Kirklees Council - Planning
Investment and Regeneration Service
PO Box B93, Civic Centre 3,
Off Market Street,
Huddersfield HD1 2JR
14 October 2020

Objection to Planning Application 2020/92400, 402 Birkby Road, Huddersfield

ELEVATION A

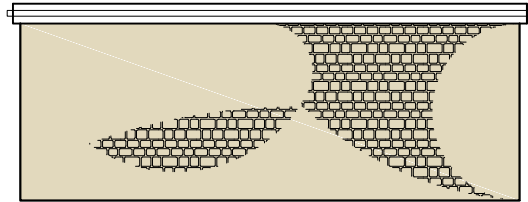
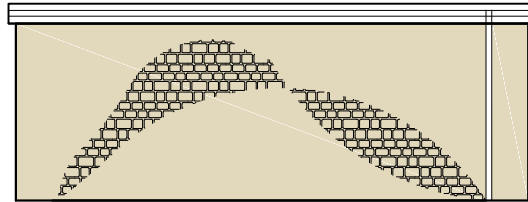
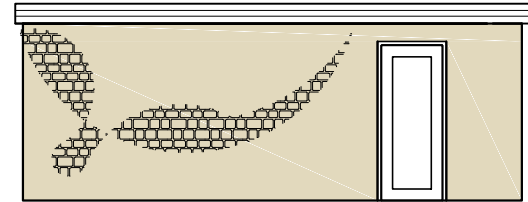
I note that the plans have changed yet again but the new ones do now show where the floor level of the garage is intended to be. The garage will still be well forward of the host property, about 1 metre above the level of the carriageway making the top of the garage about 3.8 metres above the road. Any building at that location will be highly visible from Birkby Road which is not in keeping with other properties in the local area. These measures do not address all of the issues identified by the Planning Inspector in supporting the Council's decision to reject last year's application for a detached garage. It might be a bit smaller and lower in height than the previous application and now has a flat roof, but unlike other buildings in the area, is not set back from the road and would still 'be seen as a large, prominent structure within the curtilage of a residential property'.

PROPOSED SITE SECTION (VIEW FROM BIRKBY ROAD) 1:200

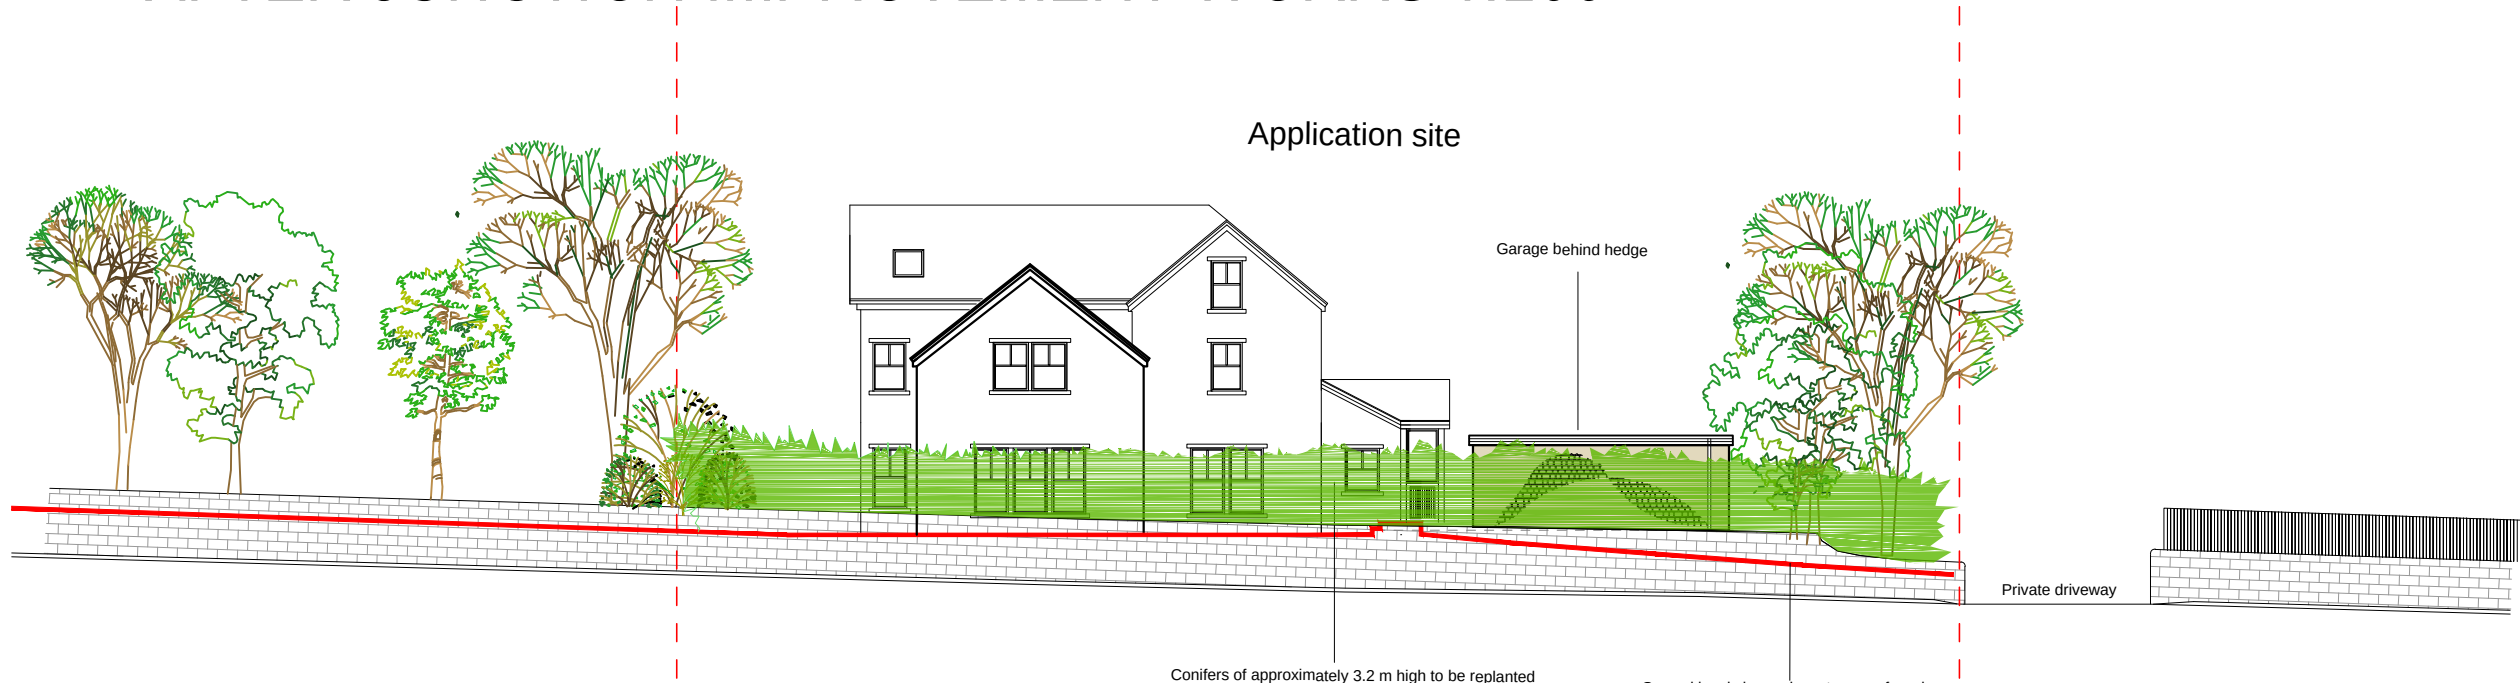
The earlier plans for this current application highlighted a hedge 3.2 metres tall which would conceal the garage. As I have previously pointed out a condition to grow such a hedge is not enforceable and therefore of no worth. The applicant is now suggesting a fence 2.6 metres high from a ground level about 1 metre above the carriageway. As I understand it, this is not part of the planning application so could only be put in place as a condition of this application. Such a condition for a fence extending 3.6 metres above the road level would not be acceptable at that location. It would be over two and a half times the maximum height for a fence adjacent to a highway without planning permission. There is a suggestion in the plan that the 2.6 metre high fence has been proposed by the Council Highways department as part of the road junction improvement scheme. As far as I can recall, this was not included in the public consultation so would require a separate planning application from the Highways Department. I continue to object to this application and believe that it would not be reasonable to approve it.
